**TOWN AND COUNTRY PLANNING ACT****HIGHWAY REPORT ON PROPOSALS FOR DEVELOPMENT**

<b>DISTRICT:</b>	Bassetlaw	Date received	27/06/2022
<b>OFFICER:</b>	Jamie Elliott		
<b>PROPOSAL:</b>	Erect Dwelling With Detached Garage and Construct New Access	D.C. No.	B/22/00696/FUL
<b>LOCATION:</b>	Land Adjacent To The Cottage Mill Lane Normanton On Trent Newark Nottinghamshire NG23 6RW		
<b>APPLICANT:</b>	Mr Roger Parker

SCALE 1:100 1:200 DATE MAY 2021 DRAWING No. 1867.A.1c

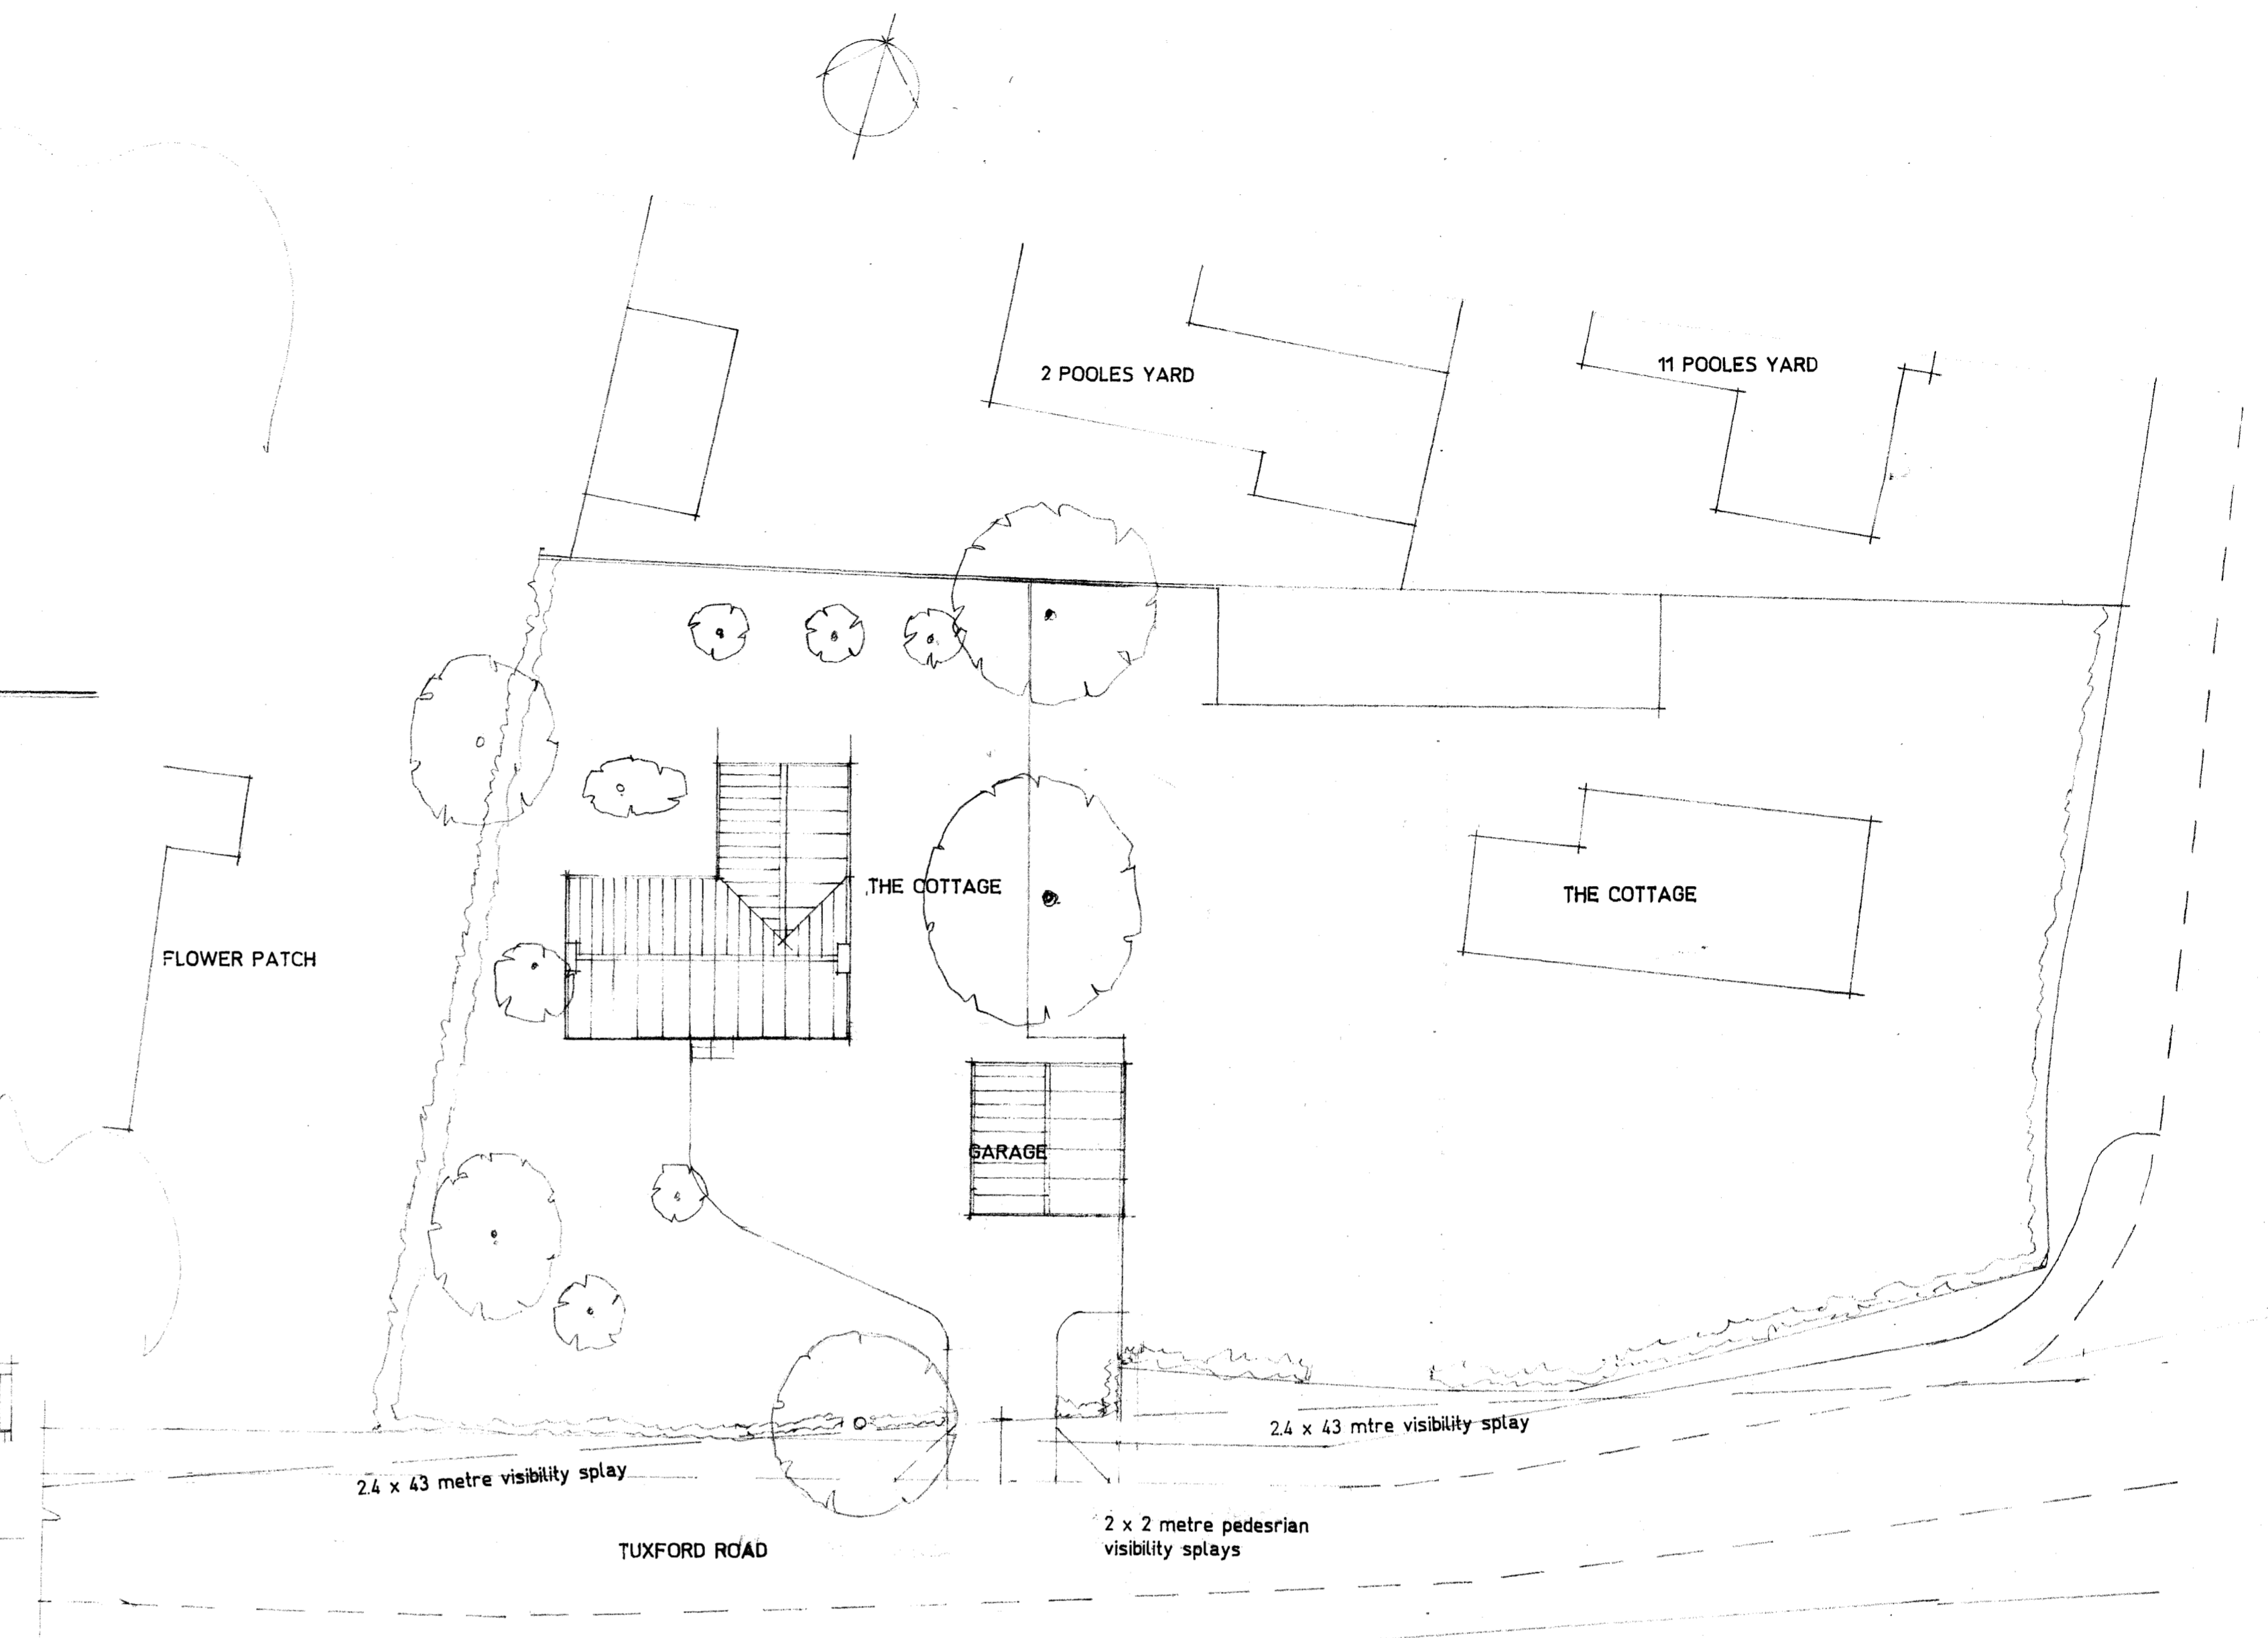
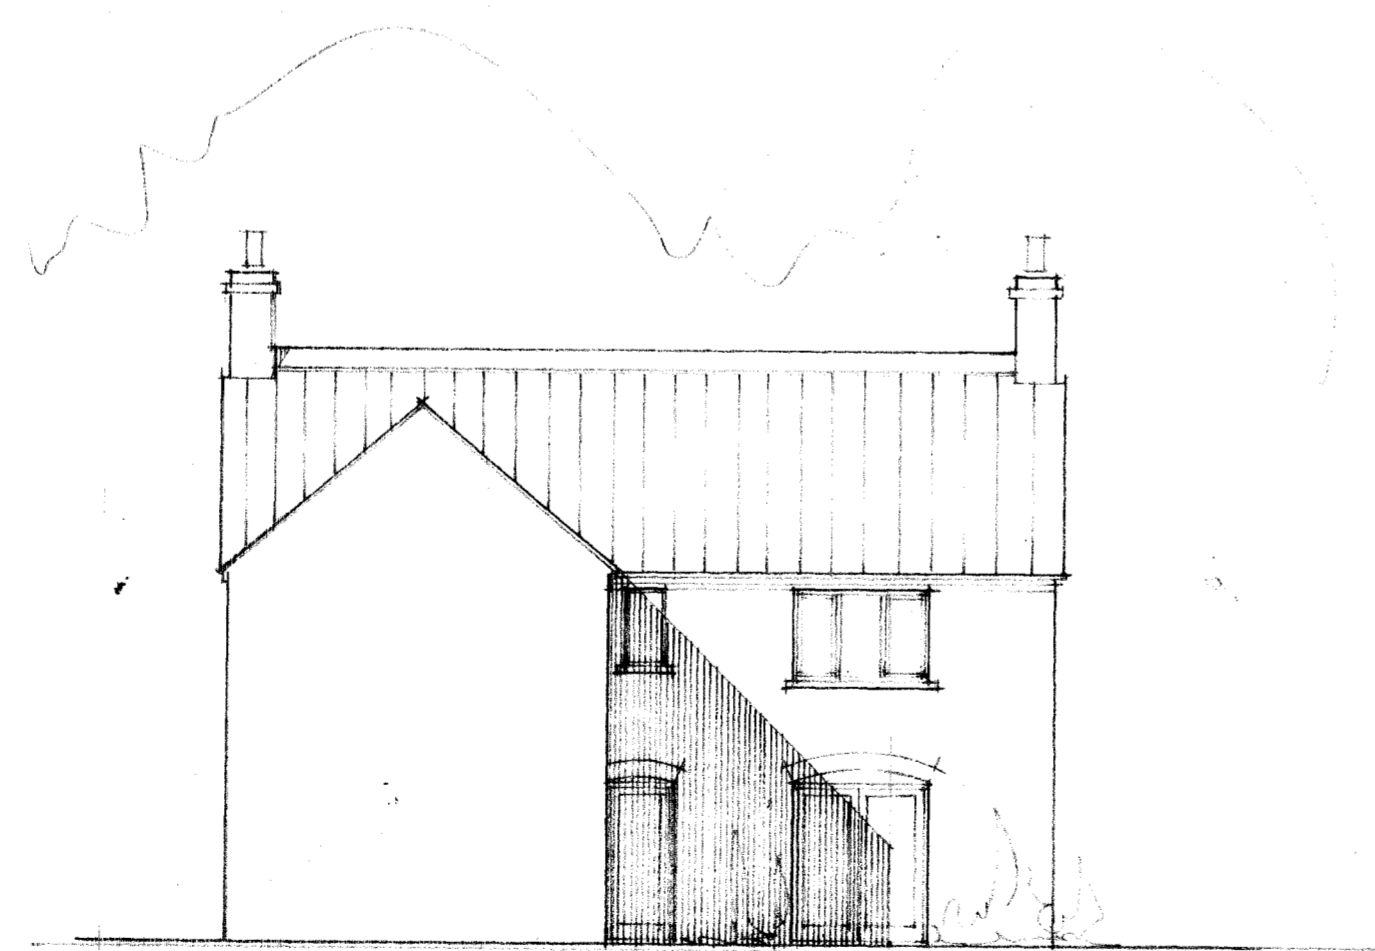
The proposal drawing reference 1867.A.1c includes the intended site access with visibility splays. Whilst the Highway Authority is content that 43m splays would be appropriate in this location, the Authority is not convinced that the plan accurately depicts the available width of the footway fronting the site. The ability to provide the visibility splay to the west within the application area is likely to be much tighter than the plan implies. The Highway Authority will require a revised plan that accurately plots; the footway width, the hedge alignment, adjacent boundaries, and the visibility splays. The latter should terminate at the nearside channel line in both directions rather than extending into the carriageway. It is likely that a great extent of hedgerow would require removing from the site's frontage.
